Subject: 2025/91770 at location Land off Station Road, Meltham, HD9 4NL

Please see ecological commentary below:

## Appendix 2: Proposed Habitat Map

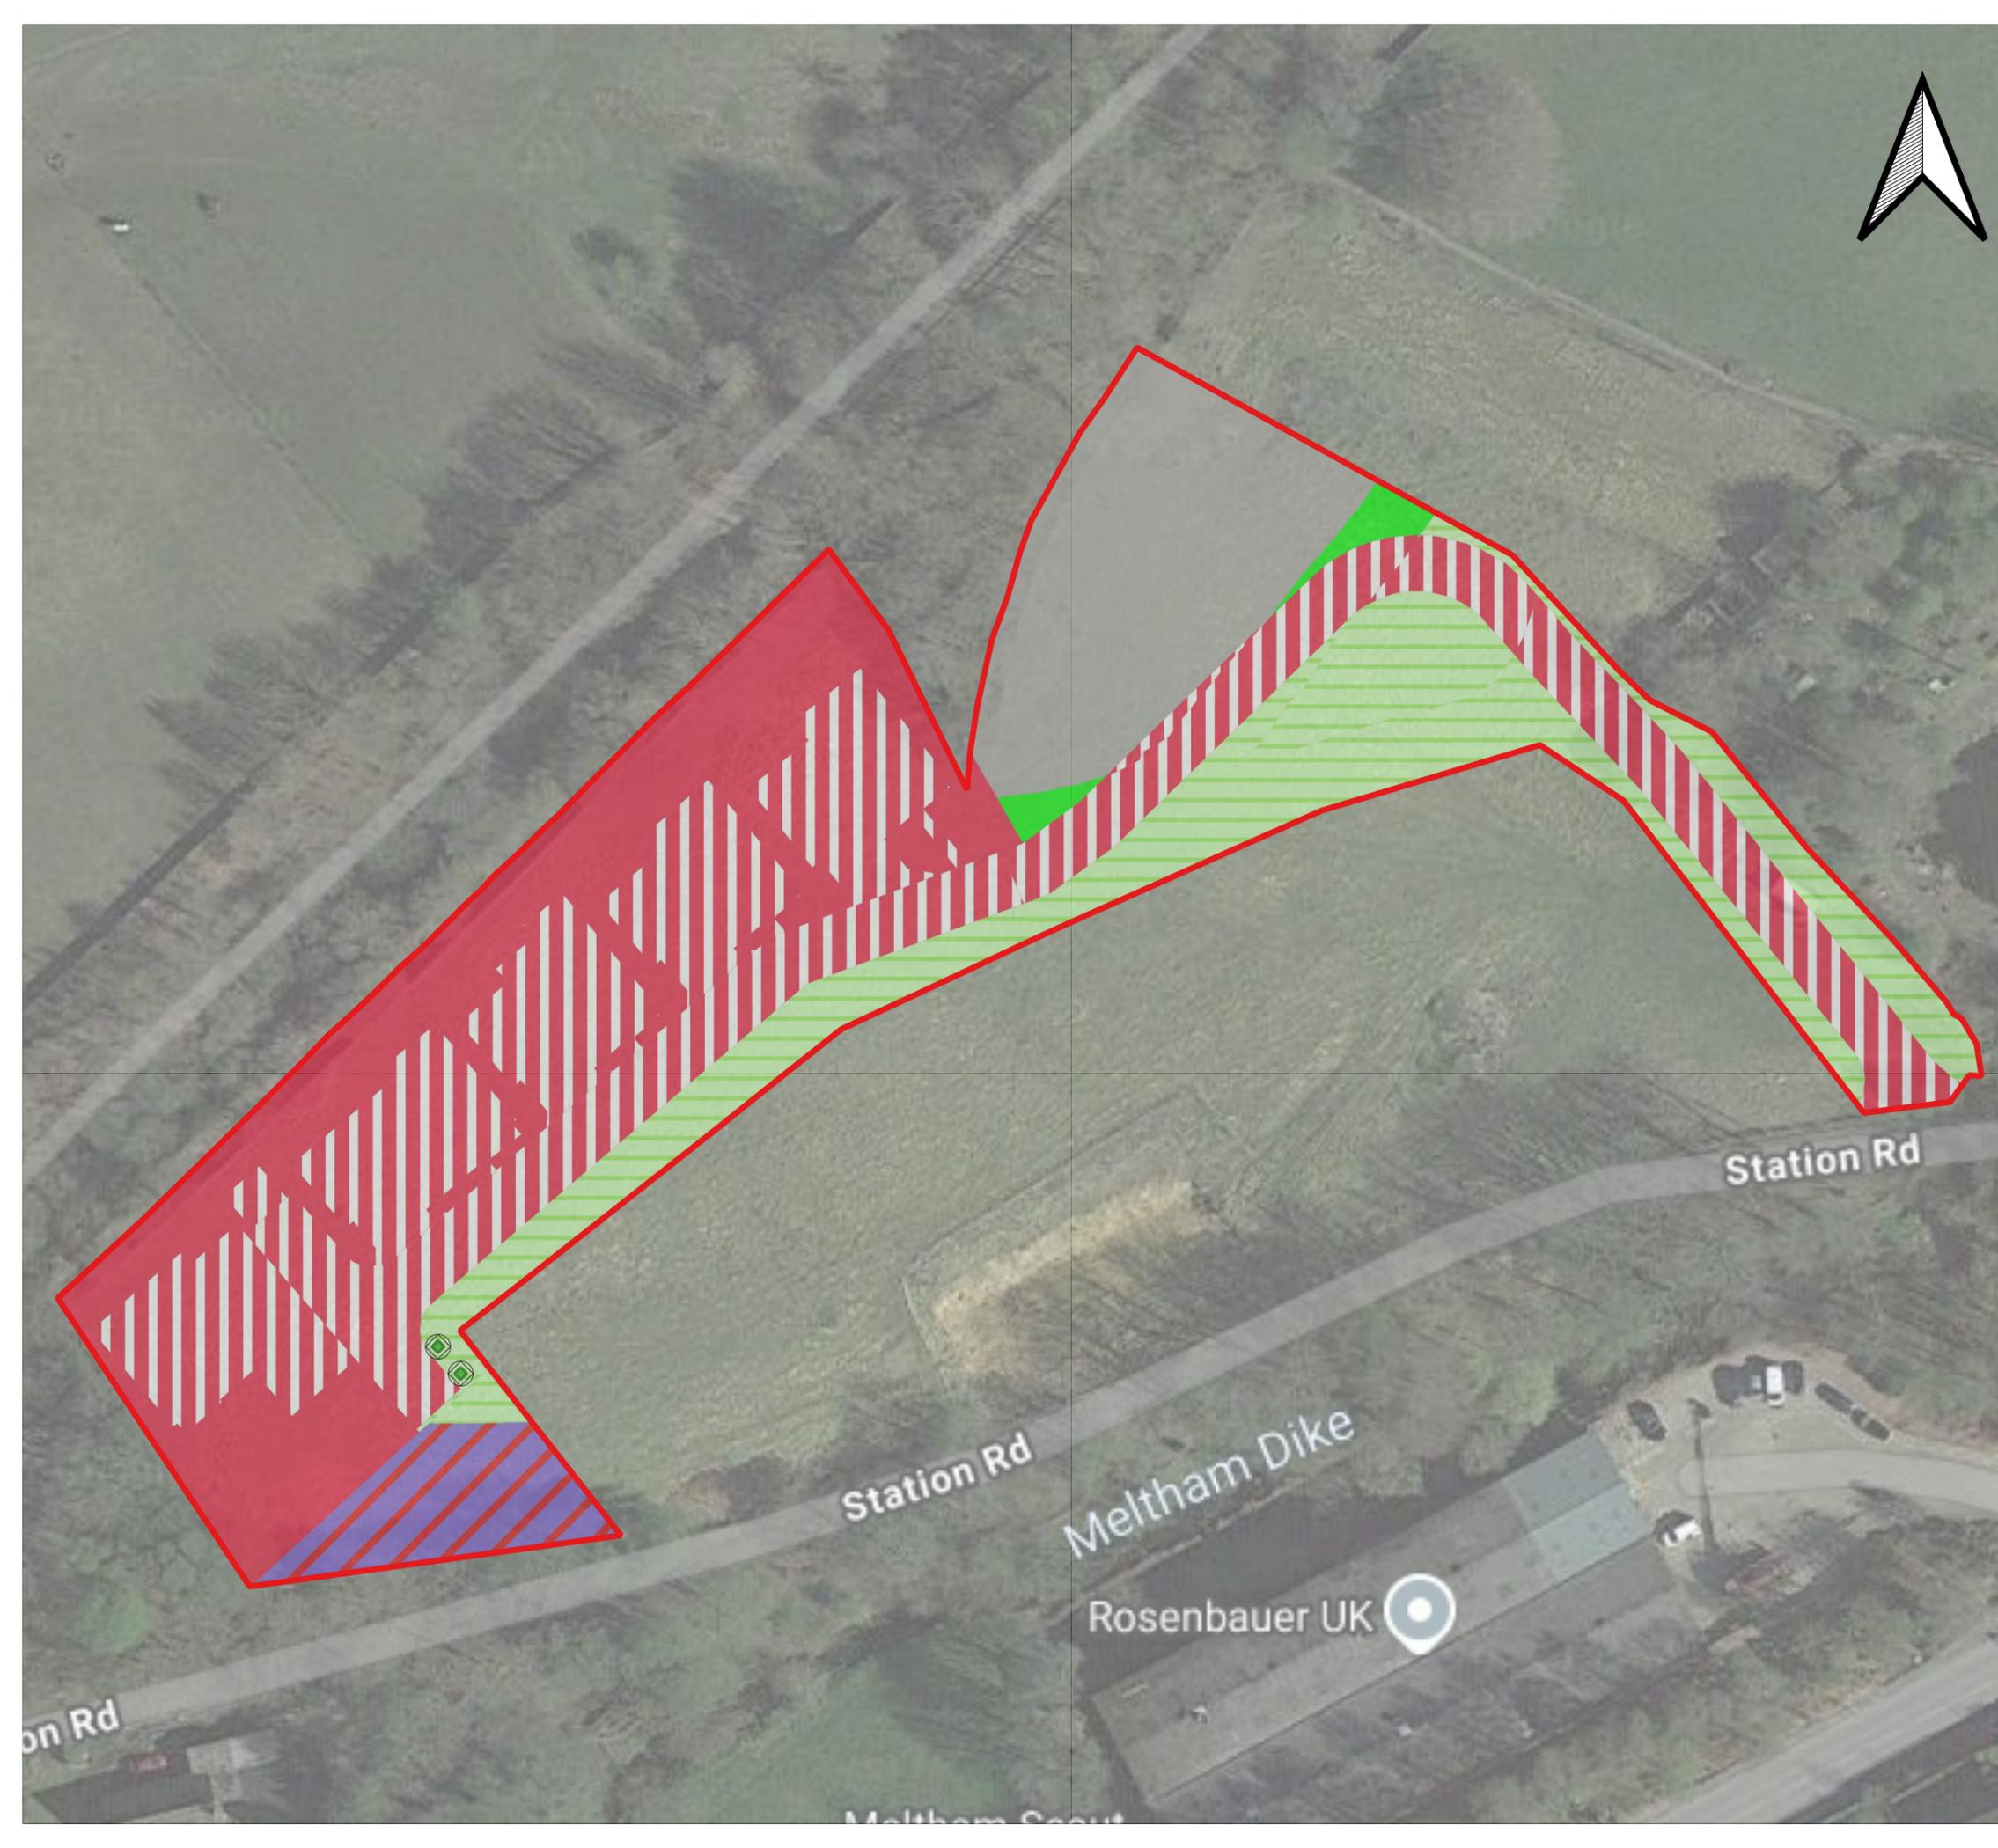
The metric areas from the baseline (0.96) does not match with the created habitat (0.77) and enhanced habitat 0.06. As a result, there is a deficit of area from the baseline at the post development of 0.13. Please can this be reviewed and / or commented on?
